Disability Access Review

The Ribbon Hotel, Serviced
Apartments and Retail

31 Wheat Road, Sydney

Disability Access Review for DA Approval The Ribbon Hotel, Serviced Apartments and Retail – Darling Harbour

PROJECT NUMBER	DRAWING NUMBER	REV
A004409	ARC-HSL-DD-1101	H

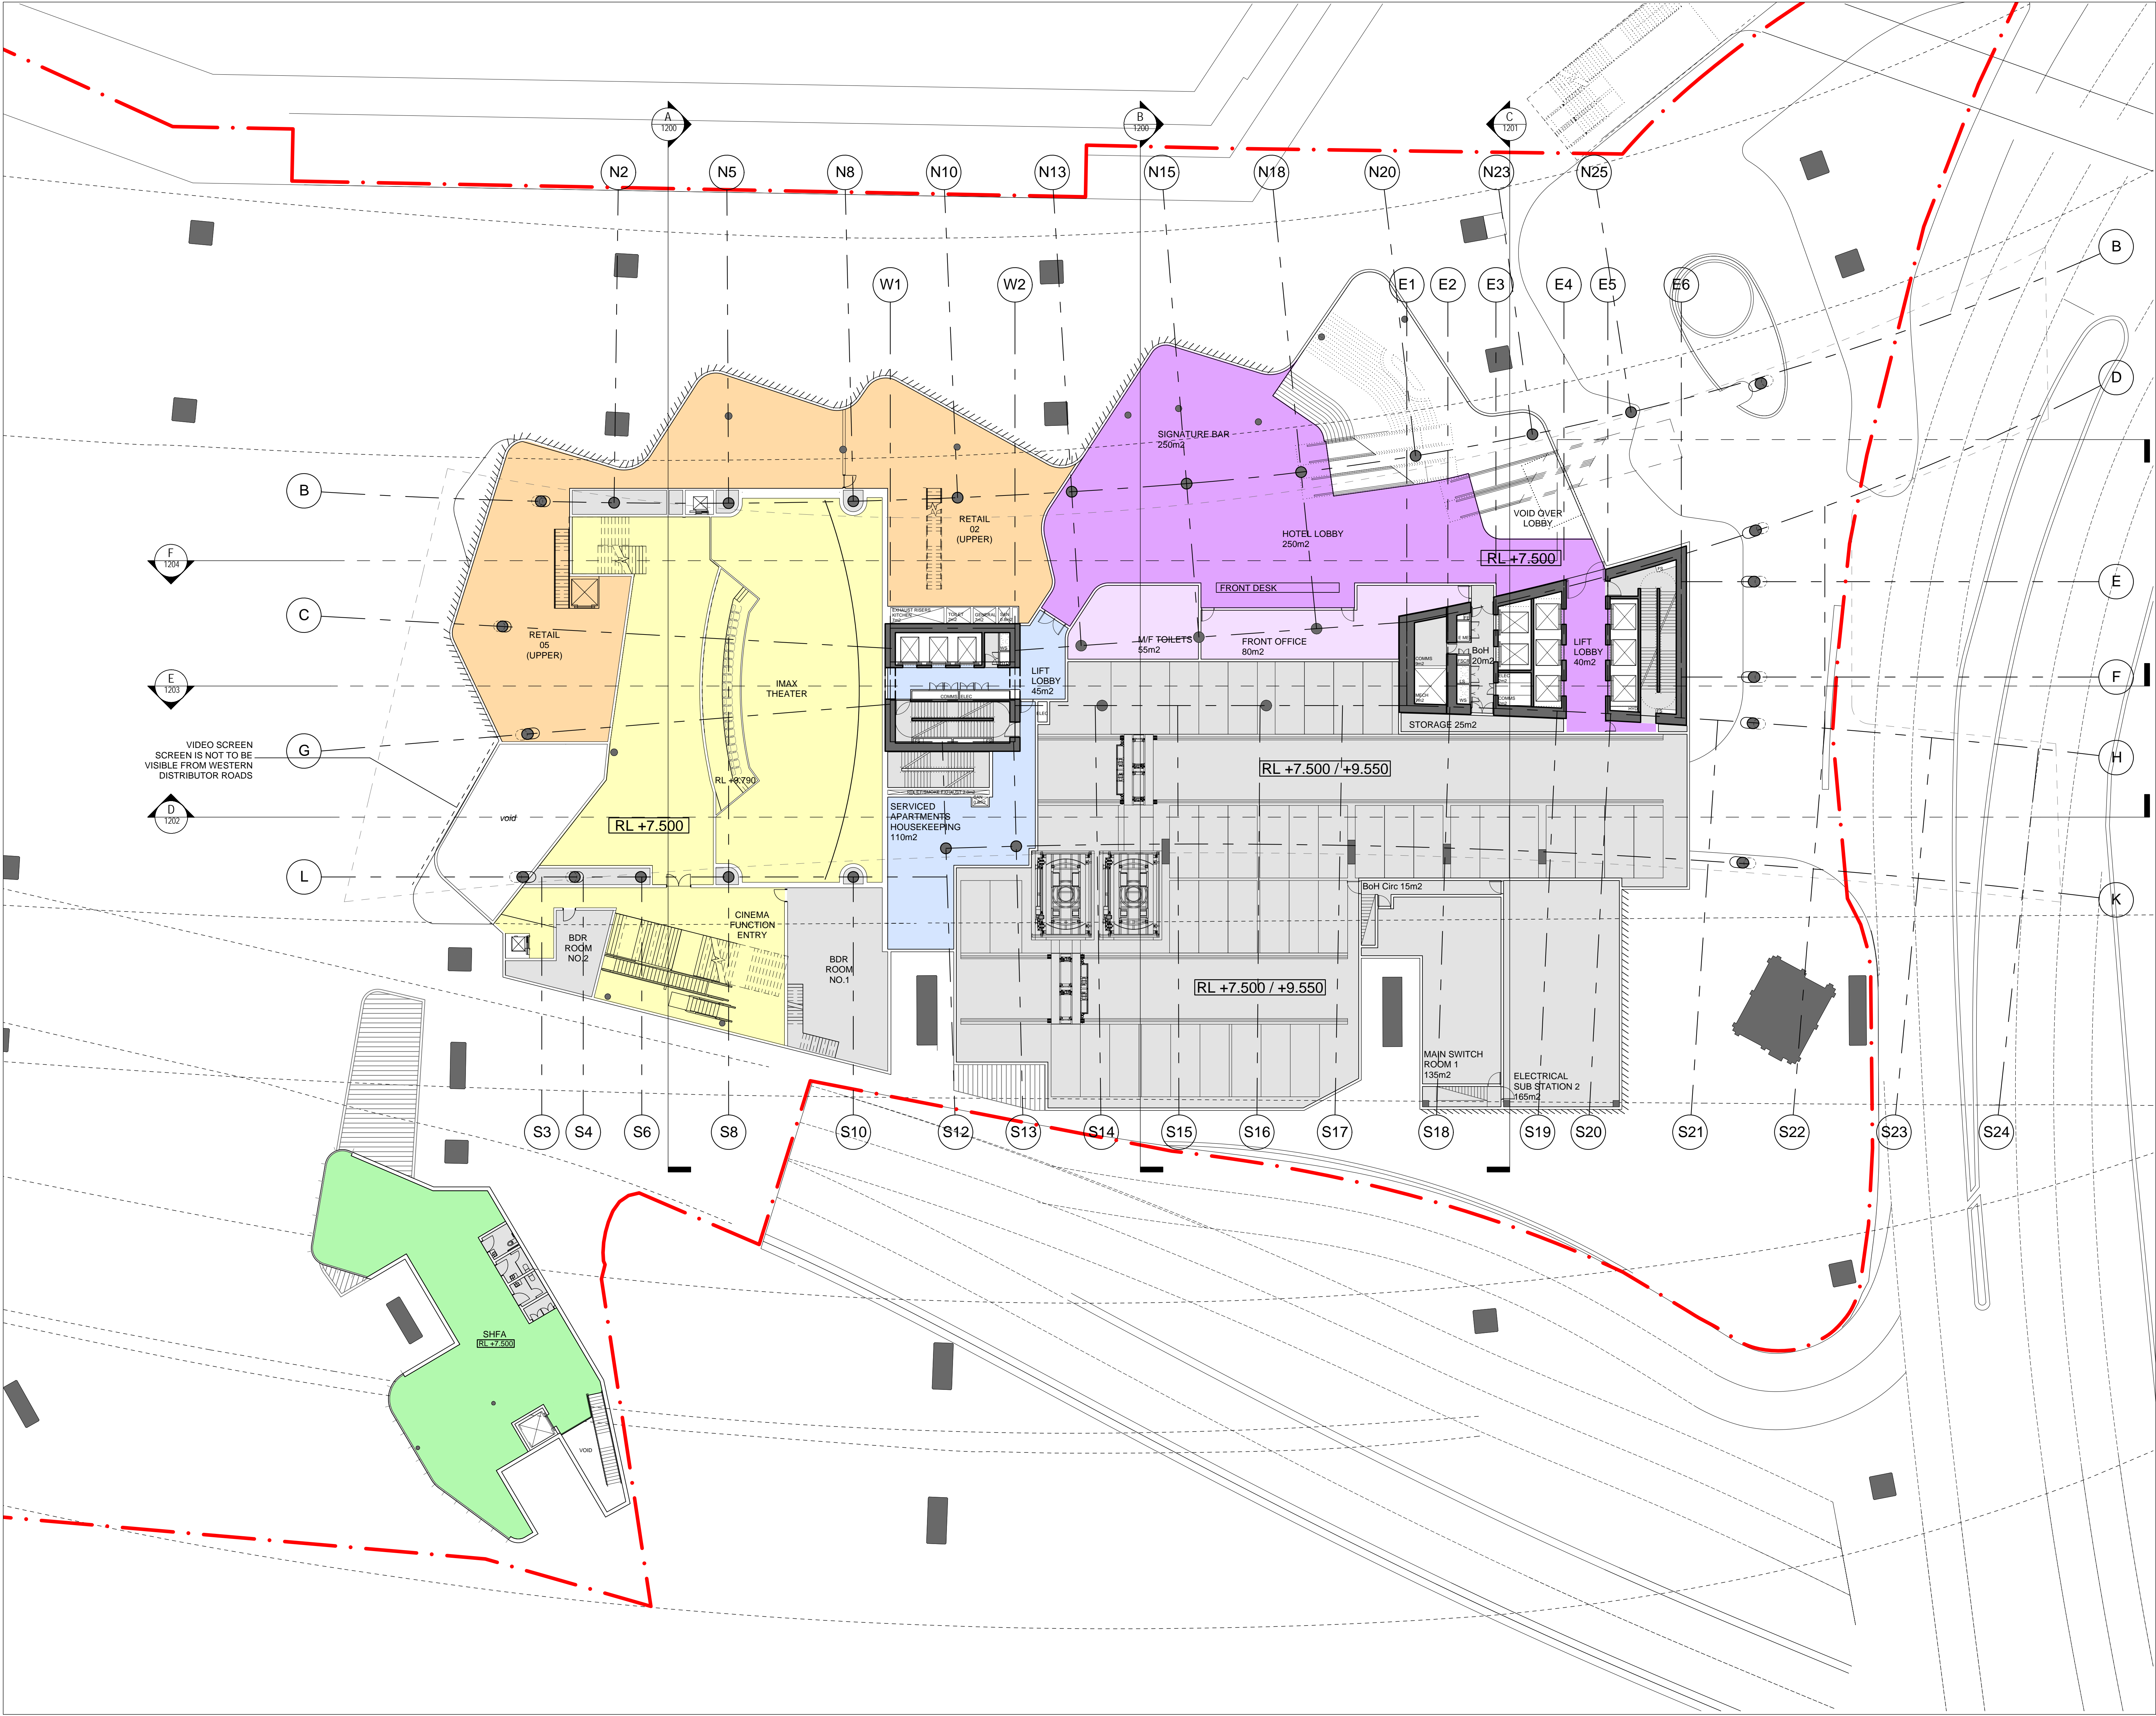
CLASS 3 – ARC-HSL-DD-1101, 1105 - 1112.1 - Levels 01, 05 – 21 Hotel and Serviced Apartments		
Hotel Front Desk location	Podium Level 01 hosts a large front desk function adjacent the Signature Bar and Lobby. These open and noisy spaces can make acoustics very difficult for people checking in and out of the hotel.	Consider acoustic treatment of the high space in terms of floor surfaces, sound absorption materials and general wayfinding for vision impaired people making their way up escalator and stairs to finding the Front Desk. Hearing augmentation would assist at the Desk.

Hotel sole-occupancy units (SOU)	The Premises Standard provides legal requirements to meet the DDA in terms of accessible room numbers and location.	The projected number of hotel room keys is 400. Under the formula given in Table D3.1, this would equal 16 accessible SOUs for the hotel function of The Ribbon. The rooms need to reflect the range of hotel rooms provided in terms of amenity and pricing.
Serviced apartment SOUs	Table D3.1 of the Premises Standard also applies to the number of accessible serviced apartments.	Currently the plan is designed for 159 serviced apartments, including single and double bedrooms. That equates to 8 accessible SOUs which need to represent each of the types of rooms available in terms of variety of views, proximity to facilities and price ranges.
Location of SOUs	For both the hotel and serviced apartment accessible designs, the Premises Standard Table D3.1 requires that no more than two SOUs required to be accessible can be located adjacent each other.	Pairing accessible SOUs near the lift bank is an asset in terms of access, particularly if the egress provisions are centred around the lift lobbies. Pair accessible SOUs as a module on various floors as in Table D3.1.

Toilet layout in accessible SOUs	It makes sense to pair the accessible rooms and to provide left and right-hand toilet pan layouts on each floor selected. Toilets do not have to look institutional and new products are catering for removable but durable use in access fit-outs.	The Access Code F2.4(g) states that where there is more than one accessible SOU, alternate left and right-handed sanitary facilities must be provided. Meet AS1428.1 requirements but this may be done through providing reinforced walls for grabrails and using removable products depending on guest requirements as long as the space is provided.
Room layout in accessible SOUs	There are many elements to consider when creating a layout for access. Circulation space in and around the bed and other furniture is crucial.	Ensure all doors in accessible rooms require only a 20N force to operate. Provide kitchenette and desk access. Ensure all controls are at 1000mm and set back 500mm from corners. Low hanging racks in wardrobes are useful. AS1428.1 and AS1428.2 provide details of compliance.

Corridors	All the upper levels have extended corridors leading to windows over the city. In effect these are dead ends. In terms of safety, it is important that a wheelchair user could execute a 360° turn when they reach these corridor ends.	It is understood that each of the SOUs has an indented entryway. This creates somewhat more space in the corridors. But it is also important to identify that the design meets the 360° turning circle for a wheelchair turn of 2250mm x 2250mm from AS1428.2 Clause 6.3. The bare minimum turn would be 180° which involves a 1540mm wide x 2070mm area to turn. See AS1428.1 Clause 6.5.3.
Double storey SOUs in serviced apartments	The plan shows designs for some serviced apartments with facilities spread over two levels.	It is acceptable to have two storeys as long as the core features of a bedroom and bathroom are available on the main accessible level.
Gymnasium	The hotel gym and the apartment gym look to have ample space for equipment. Card access to the gyms needs to be set back from any corner by 500mm.	As best practice, vision impaired people prefer not to have large walls of mirrors so opaque walls are preferred for glare minimisation. Also layout of equipment on contrasted colour floor surface is a boon to wayfinding in gym use.

PROJECT NUMBER	DRAWING NUMBER	REV
A004409	ARC-HSL-DD-1102	E

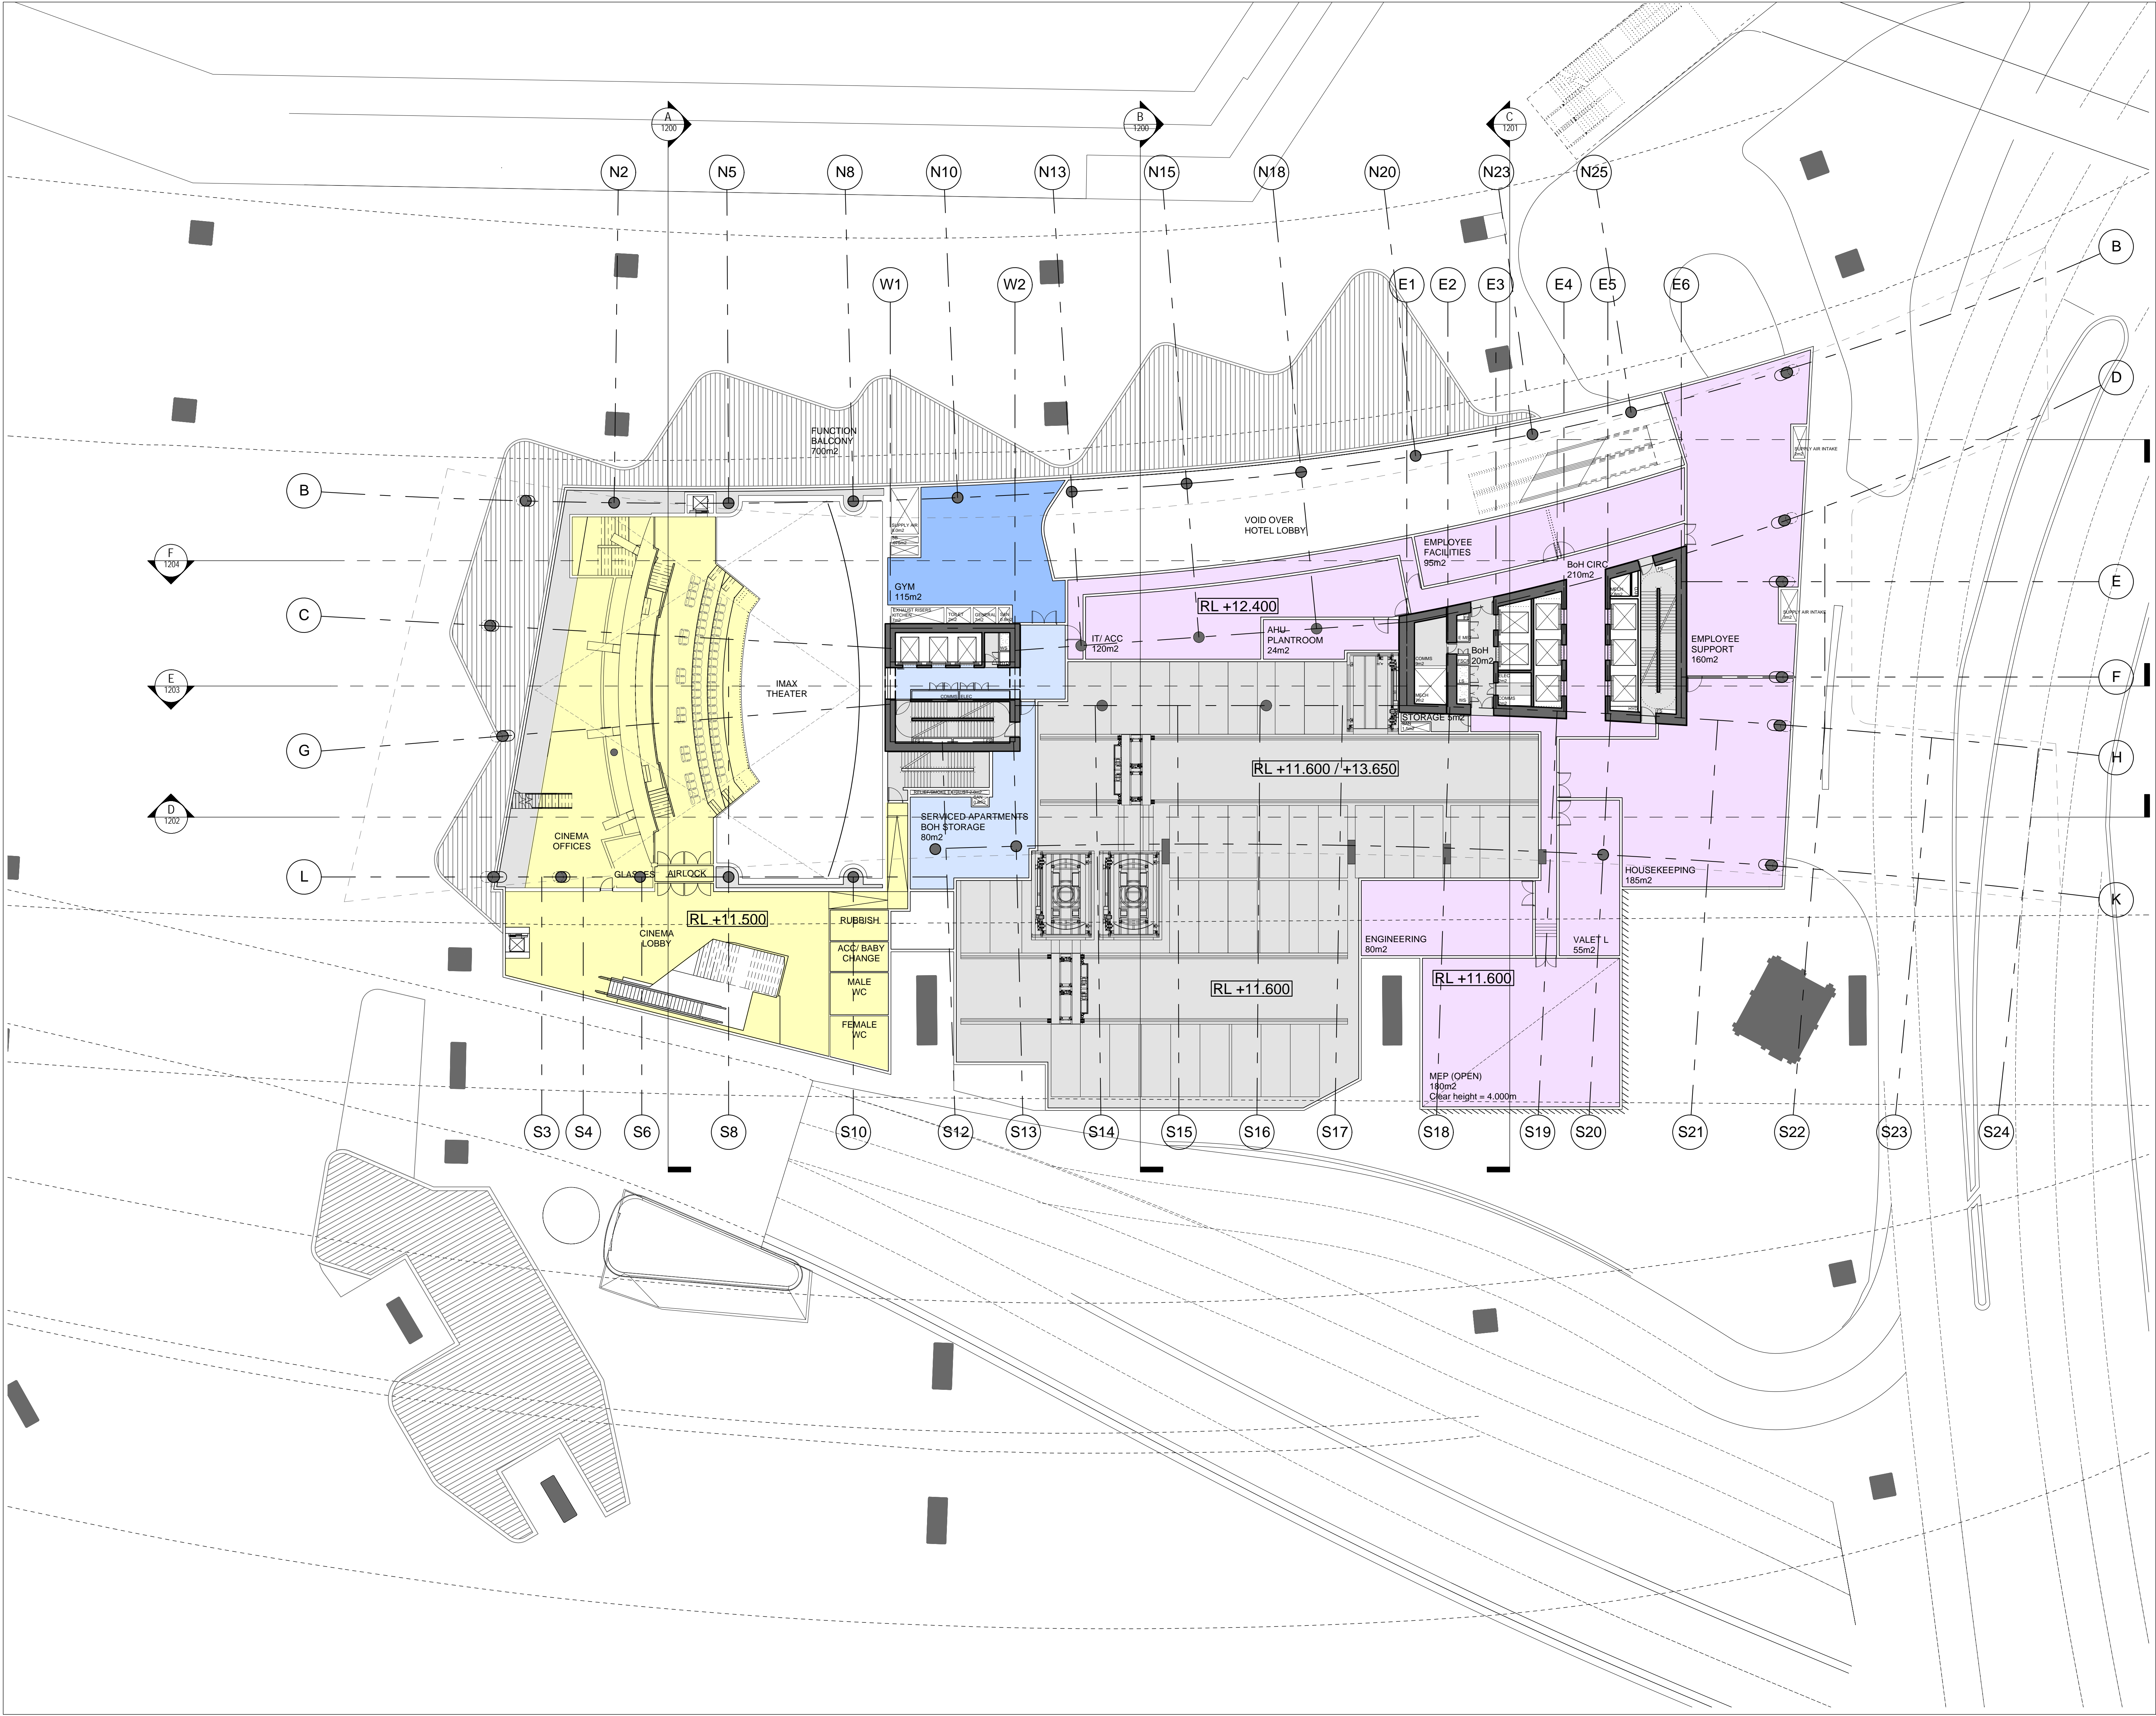
CLASS 9b - ARC-HSL-DD-1100-1102 Ground, Levels 01-02 IMAX and Level 04 Ballroom		
IMAX entry and exit lifts	The plan shows two lifts at the IMAX cinema, one for entry and one for exit following the one-way normal circulation of IMAX cinema management. This is an excellent part of the design and will increase audiences of people with disability, friends and family.	In a large public facility it is also important that the lifts are long enough to accommodate a stretcher for evacuation. Keep rear lift wall free of handrails to provide length and adjust side handrail height to not directly conflict with stretcher heights. Ensure that the lifts on either side of the IMAX complex meet Premises Standard Table E3.6 (b) for passenger lifts which reference AS1735.12 features.

Stairs and escalators	For public safety, it is important that stairs and escalators incorporate the best in accessible design, including yellow nosings on the front of escalator steps and sides.	AS1428.1:2009 provides technical guidance on compliance with stair design, including stair nosing profile, tread dimensions and contrast, handrail design and use of TGSi. See AS1428.1 Clauses 11 and 12.
Signage	Prominent directional signage will be required to assist patrons to find the stairs, escalator and lifts which are largely set behind columns.	Signage other than for sanitary facilities and hearing augmentation is not covered by the Access Code but remains open to complaint under the DDA. Use best practice principles of size of text by comfortable viewing distance, height of placement, reflectivity, luminance contrast, arrow style, pictograms, illumination, etc. See Draft AS1428.4.2 for more information

Columns in circulation spaces	Inclined columns are prominent in the Foyer and large retail area on the ground floor.	Use a combination of TGSi and luminance contrasting to increase safety. Avoid reflective surfaces that can hurt the eyes of vision-impaired people in brightly lit spaces.
IMAX cinema accessible seating space numbers	Table D3.9 of the Premises Standard gives a formula for calculating the number of wheelchair seating spaces in Class 9b buildings. For a cinema of 450 seats, it calls for 3 seats up to 151 customers, then 1 space for each additional 50 seats.	There are 9 accessible seating spaces for the IMAX. The Design Development plan is compliant with Table D3.9. Seats are at the preferred viewing location and none are in the first row which is prohibited under the Premises Standard. The space allocated for accessible seating also provides room for an assistance animal.
IMAX accessible seating distribution	The grouping of the wheelchair seating spaces is to be not less than 1 single space and not less than 1 group of 2 spaces and not more than 5 spaces in any other group.	The IMAX design aims to give wheelchair users a premium experience by locating spaces at the optimal viewing distance from the large screen on the cross-over level and ensuring that the majority of seats (7 of the 9) are located centrally. The other two are still considered in an excellent viewing position.

The design for accessible seat grouping complies with the Premises Standard D3.9 (b).
IMAX accessible seating location	D3.9 (b) (iii) states that the location of wheelchair seating is to be representative of the range of seating provided. Attention to equitable access and egress with lifts at north and south ends makes this a very desirable entertainment experience for people with disability.	The cantilevered design of the Darling Harbor IMAX does not allow any lift access to the top tiers for an alternative location. Similarly the front row is not deemed to be a desirable location in an IMAX size screen. The design solution to keep all wheelchair spaces on one level has been made within the limitations of the site but aims to provide a gold level experience with 9 wheelchair seating spaces and companion seating in the best viewing spot and ease of access and egress.
Hearing augmentation in the cinema	Hearing augmentation is required for the cinema. Depending on the mode chosen, a loop should cover 80% of the floor area and a system using receivers to cover 95%.	Select the mode of delivery of hearing augmentation and comply with the Premises Standard D3.7 (2). Display of the type of hearing assistance is mandated to be signed outside the cinema in raised and tactile signs (D3.6). See AS1428.5:2010 Figures 5.2 (A) and (B) for detailed examples of text and pictograms to incorporate.

Public address systems	The IMAX screen must be capable of supplementing any public address system, other a public address system used for emergency warning purposes only.	Explore the use of captions for emergency warning and other purposes to comply with the Premises Standard D3.7 (4) so people who are deaf or hard of hearing are not discriminated against by audio only information.
IMAX accessible toilets	The Sketch Design shows a unisex accessible toilet adjacent the male/female toilet banks on both levels.	Ensure that the two accessible toilets in the IMAX complex have alternated handing, left and right transfer. Consider providing automatic door controls and locks that have come down in price recently with adoption across the country to aid access and security.
Parent Facilities at IMAX toilets	The plan shows baby change facilities incorporated in the unisex accessible toilet.	Meet AS1428.1-2009 Clause 15.2.8.2 for baby change tables if installed. Sign externally with raised tactile Braille pictograms affixed adjacent the latch side.
